Our Ref : S076158.015

File No : MP10\_0104

**RE West Circular Quay Public Domain Upgrade Works, Circular Quay /  
The Rocks (MP10\_0104)**

The City has reviewed the Environmental Assessment and notes the conceptual nature of the proposal. The City generally supports the design concept but cannot give its full support to the proposal in its current form due to the lack of design resolution and detail relating to some key aspects of the proposal.

4 . Shade and trees

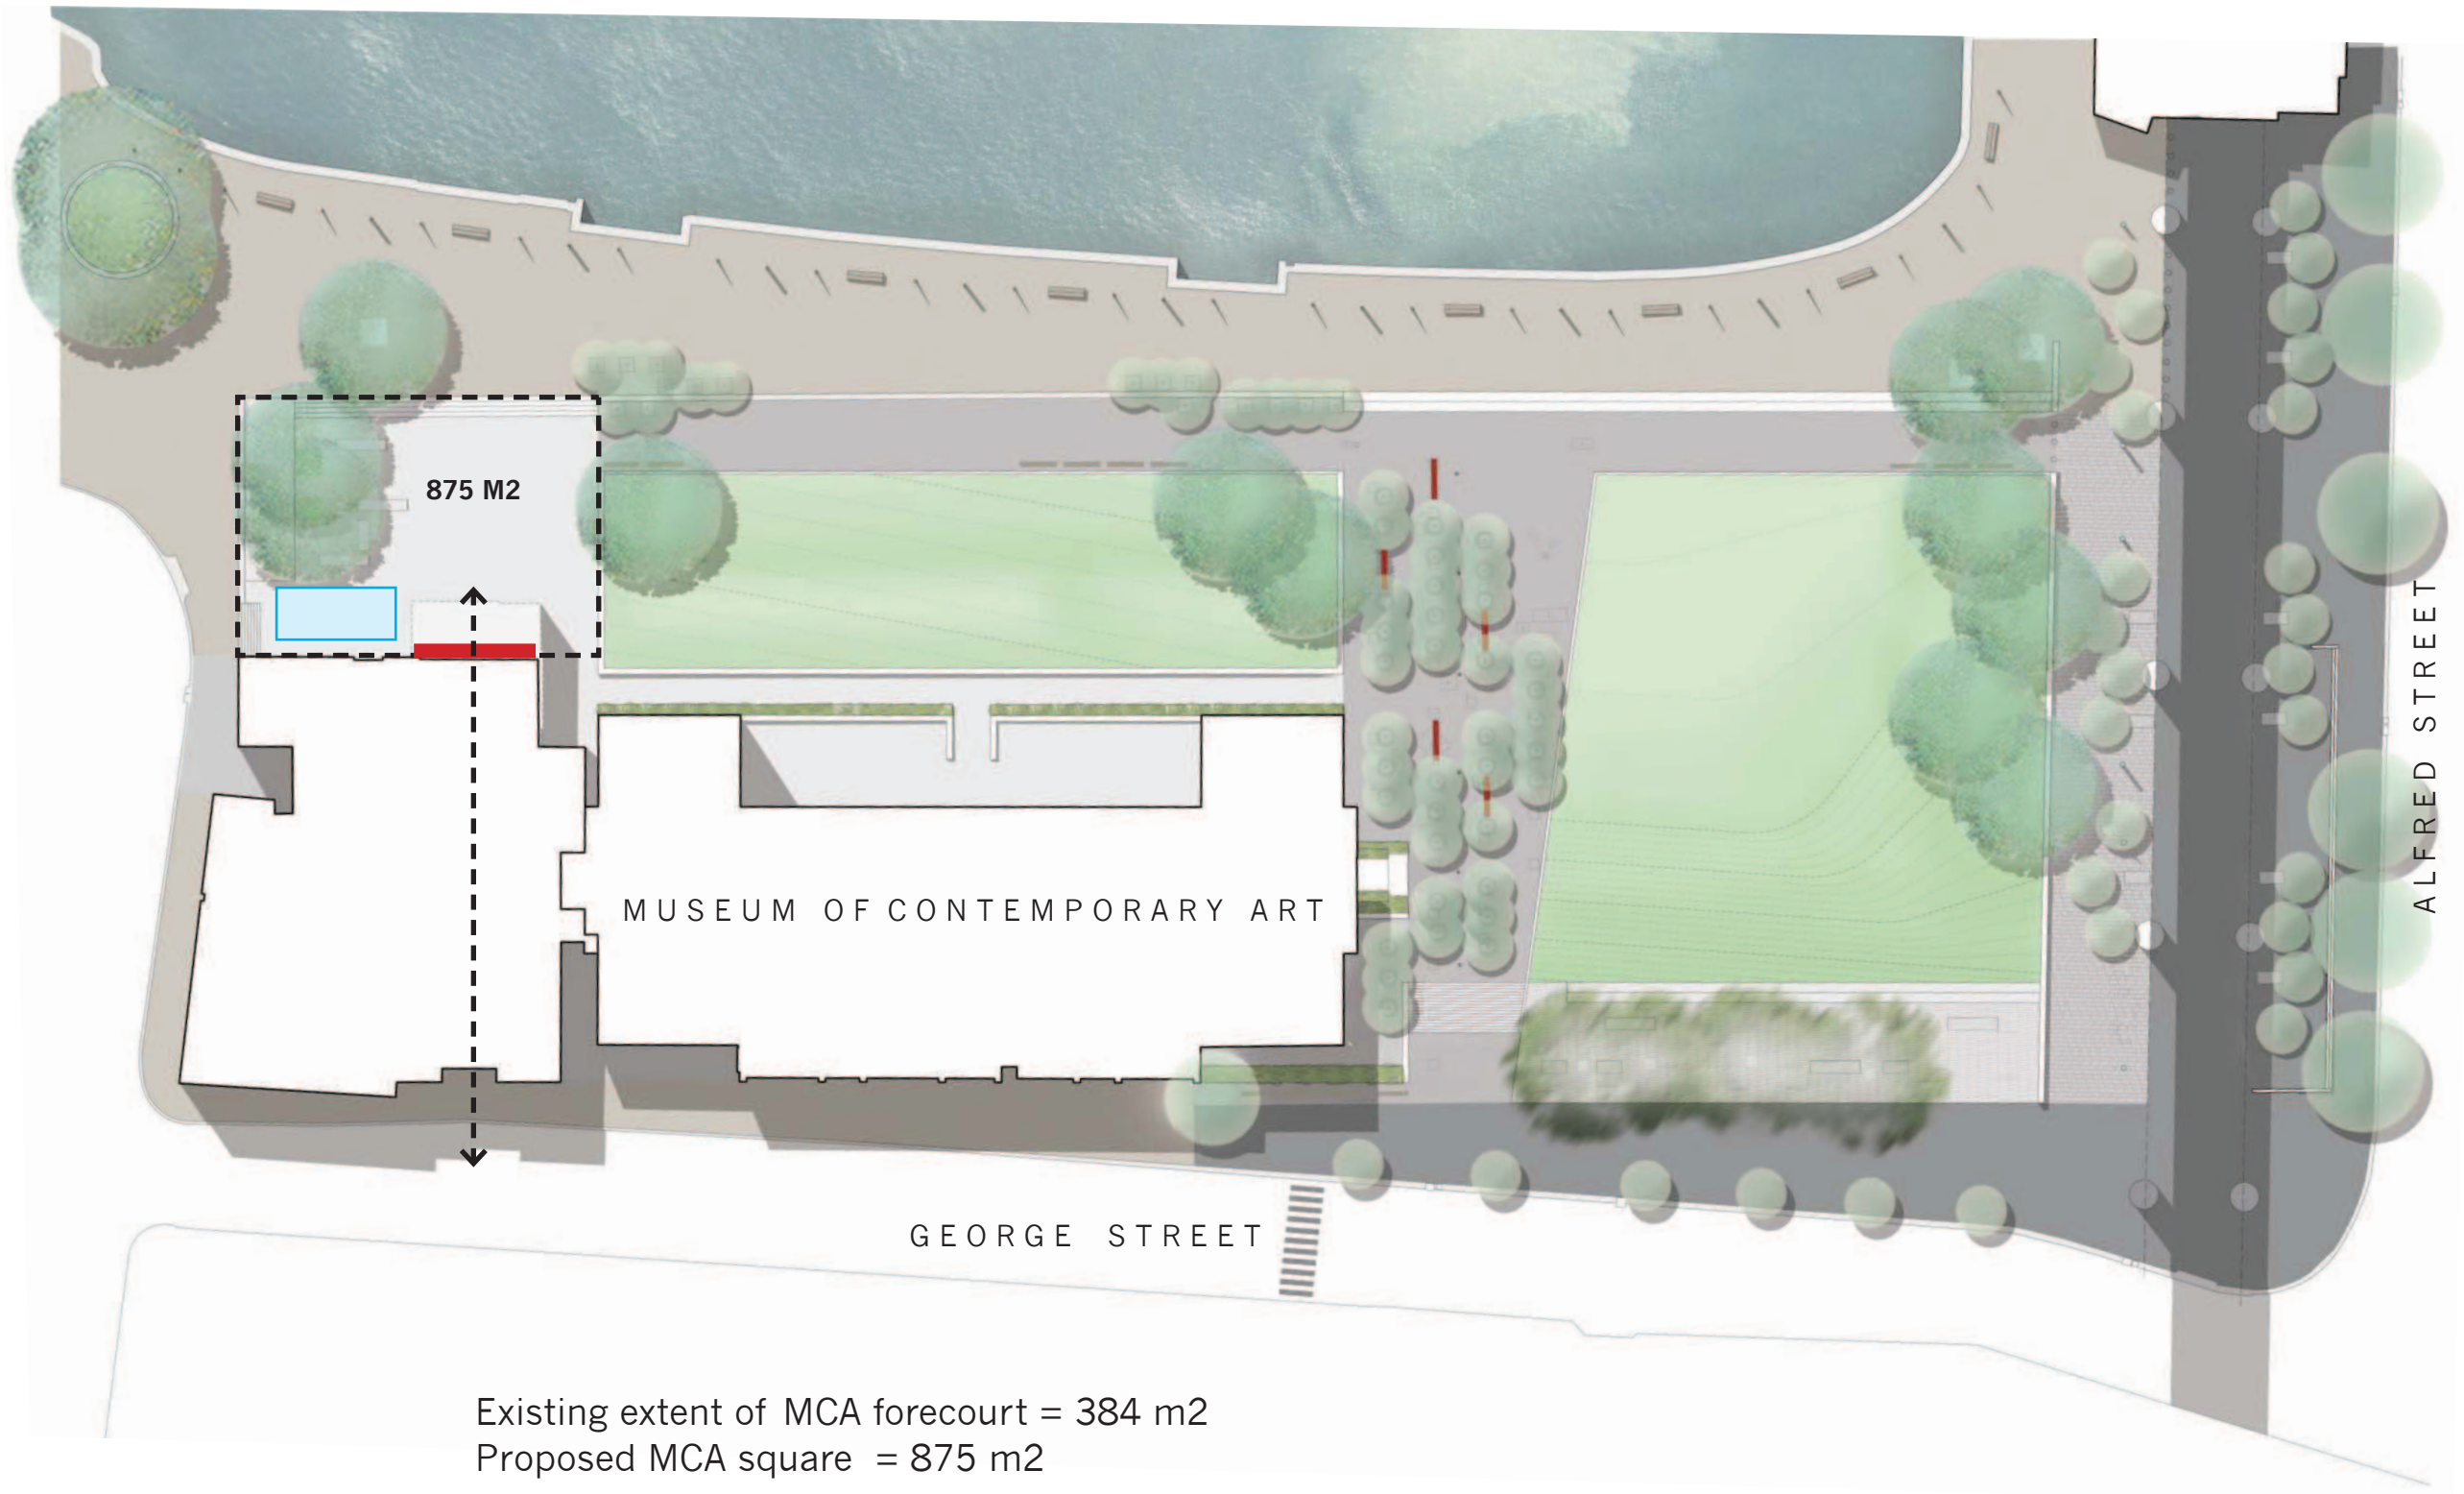
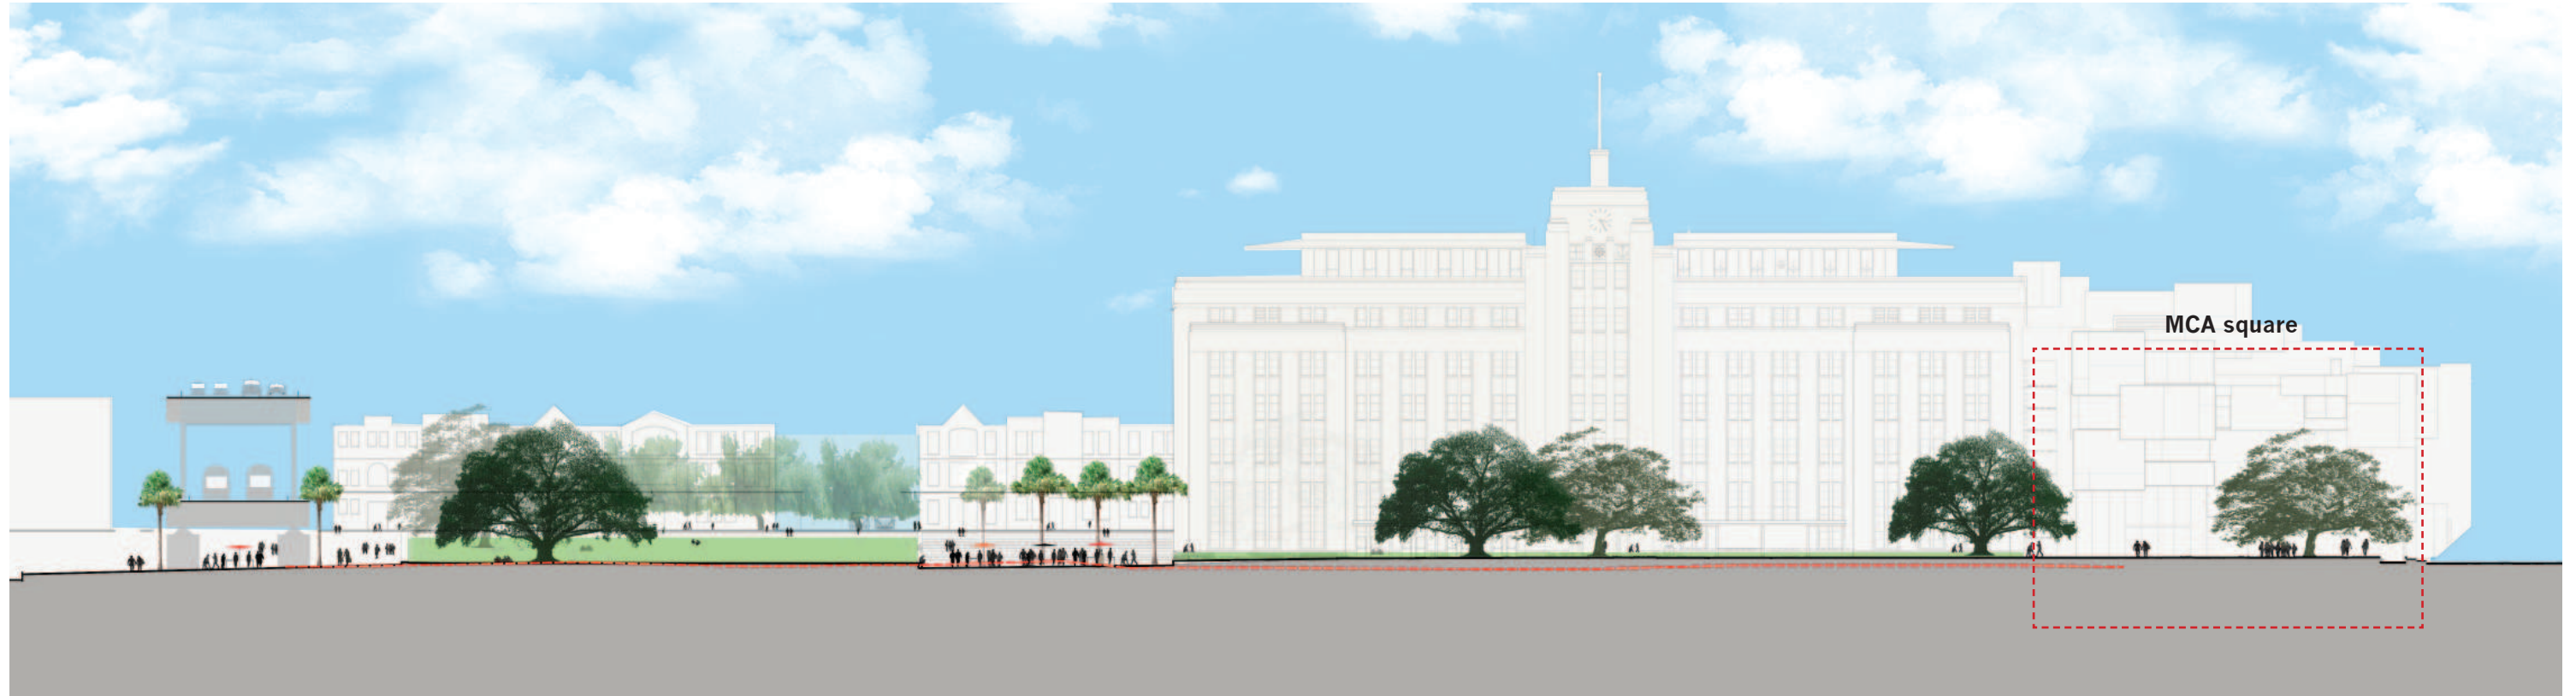
- a. The removal of any Pepper trees is not supported until further investigation is made into the health, condition and stability of the trees as recommended in the arborists report.
- b. Consideration should be given to the provision of more shade and shelter around the edges of “The Green” which experiences significant sun exposure during the warmer months and high levels of use by families and children.
- c. A detailed landscape plan is not provided at this stage. A plan should include but not be limited to details of tree species selection, planting specifications, earthworks, maintenance and drainage systems.

5 .Seating

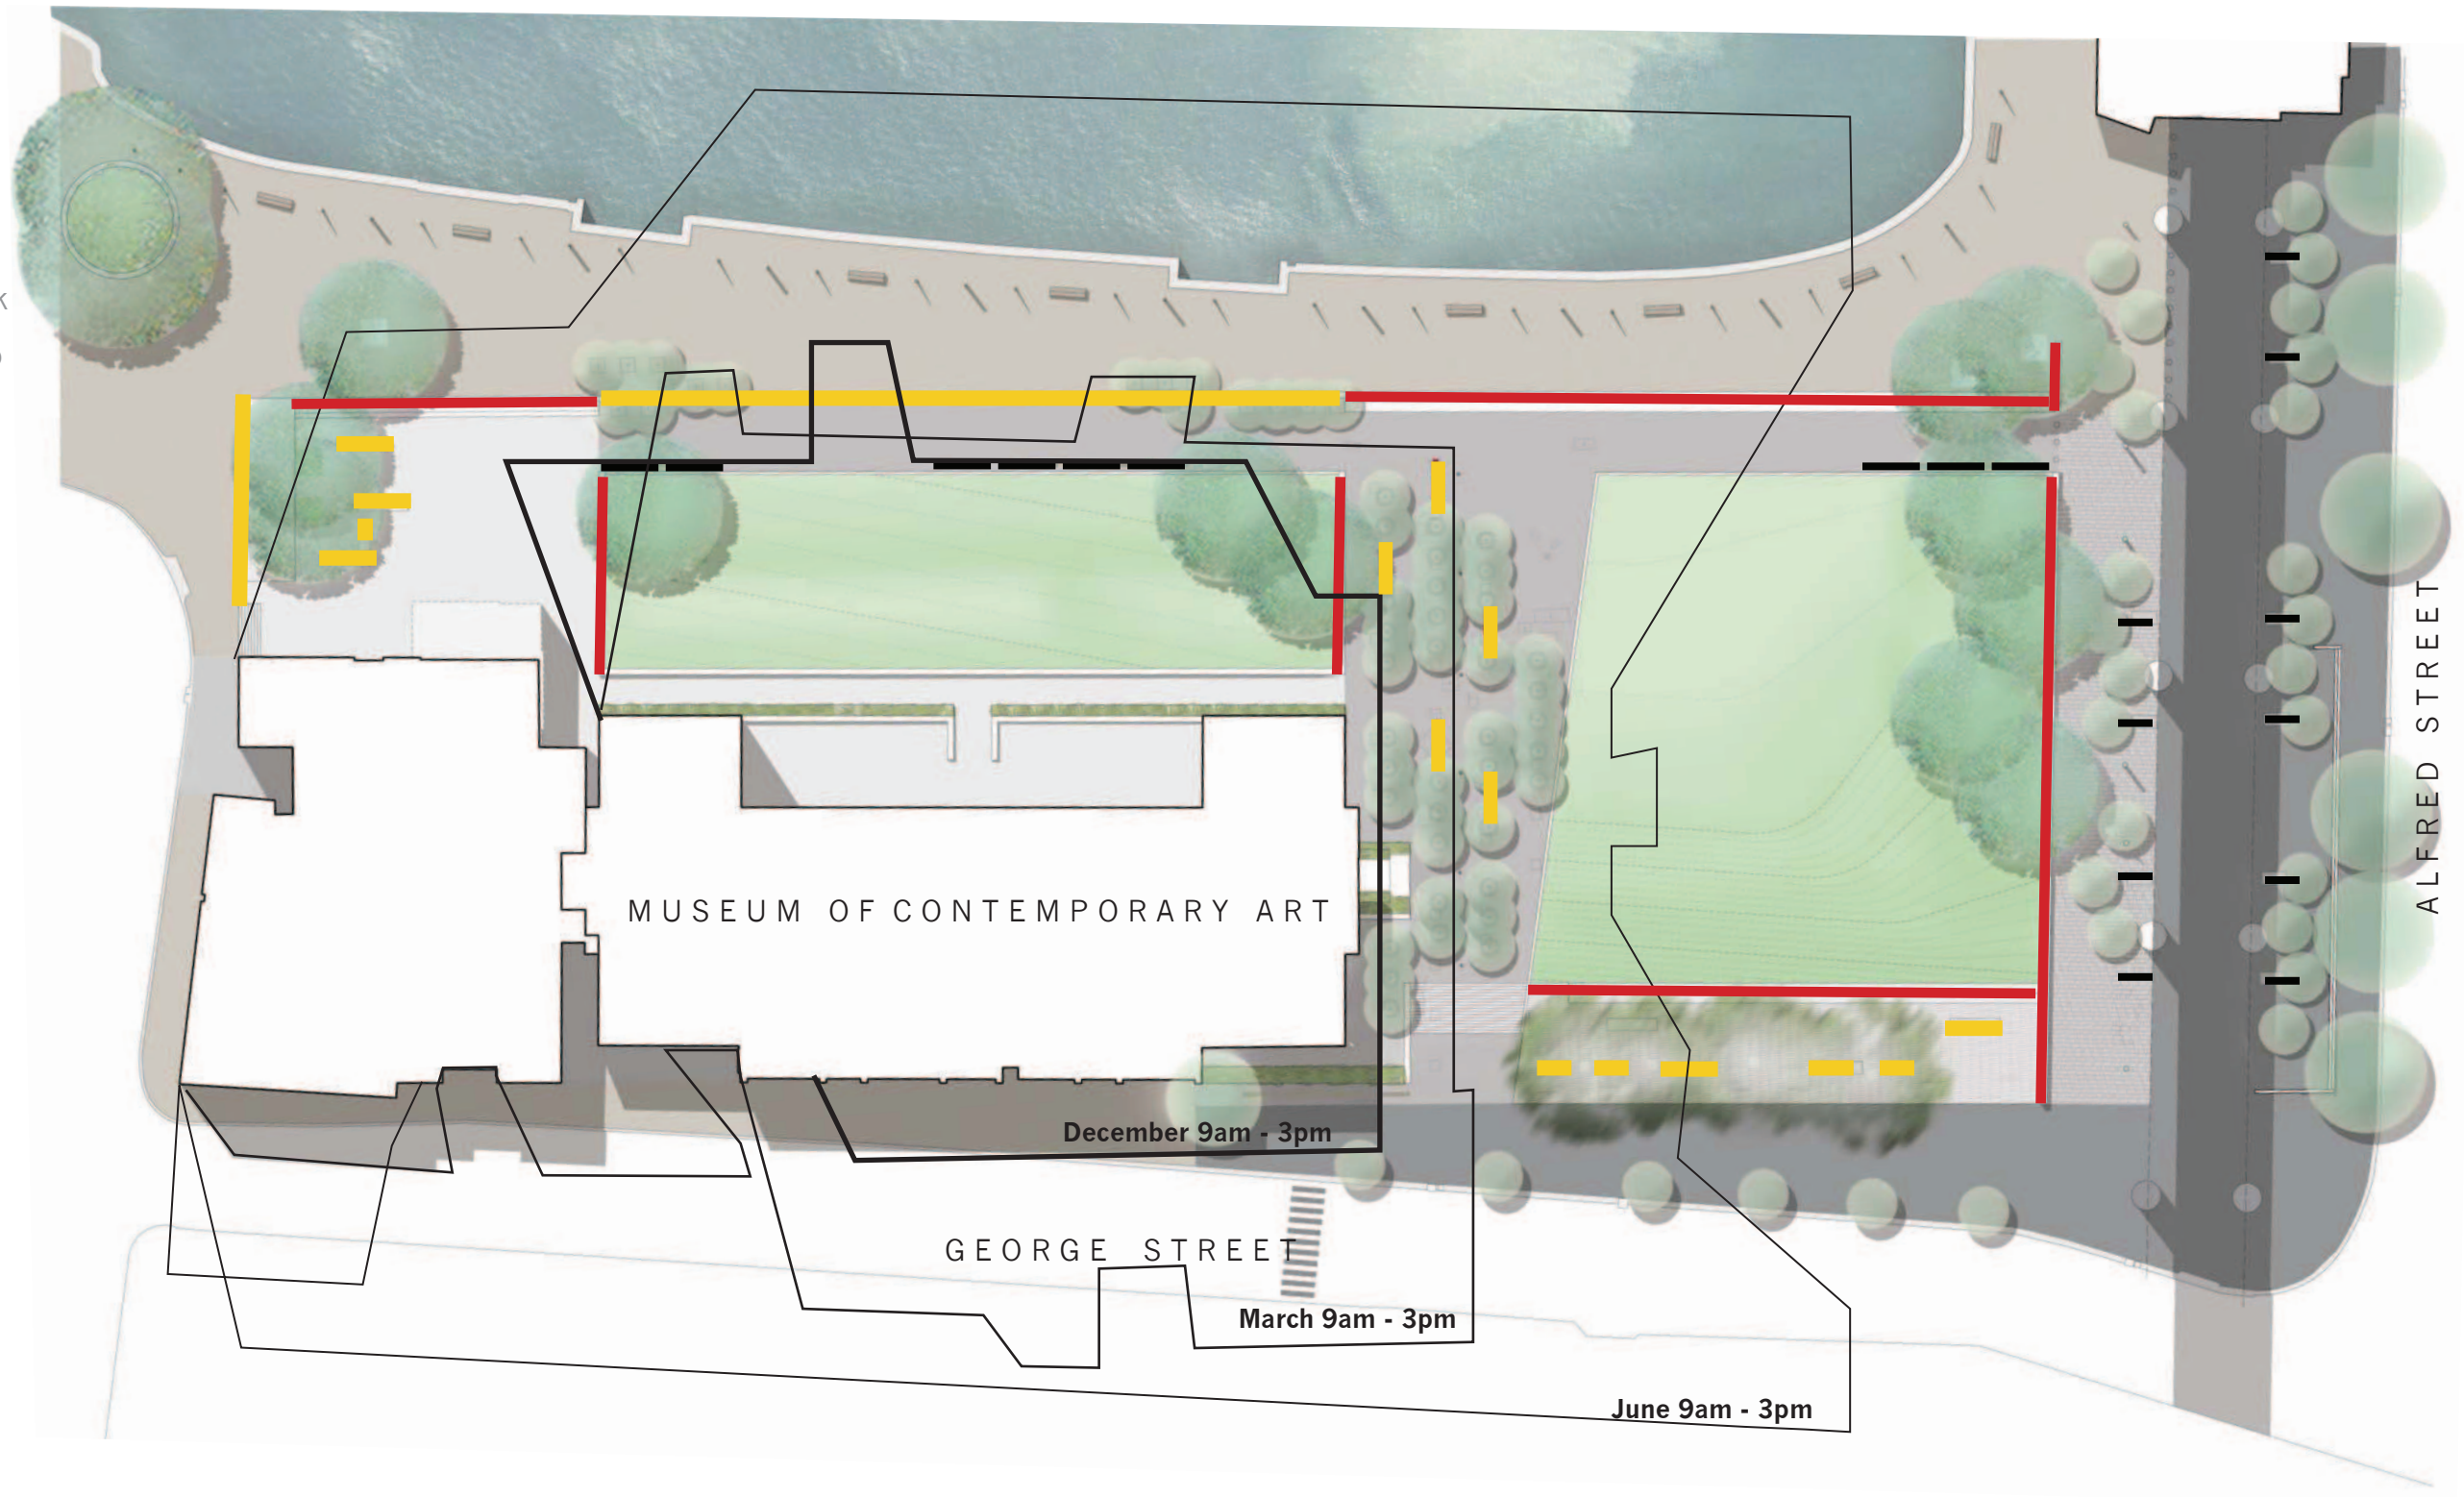
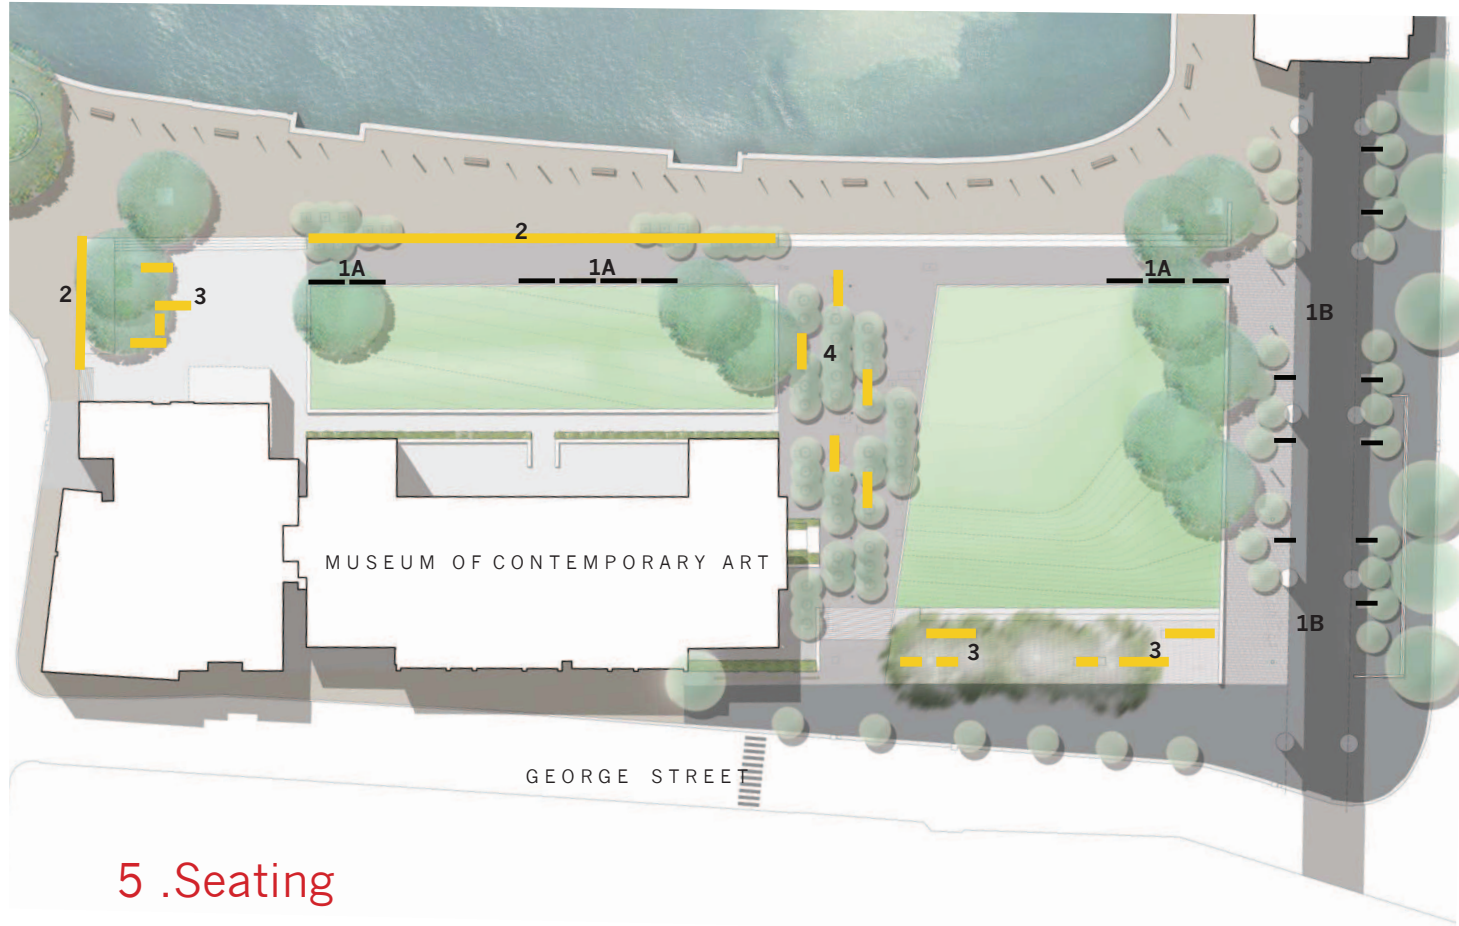
- a. The finishes on benches may not be appropriate. In particular, the paint finish on concrete benches should be changed to a more robust finish, and the “red gloss paint finish” at “Market Wharf” should be reconsidered.

- b. Inadequate details are provided about the street furniture; in particular, clarification is needed about “standard benches” and whether the concrete benches contained in the documentation are proposed or illustrative precedents only.
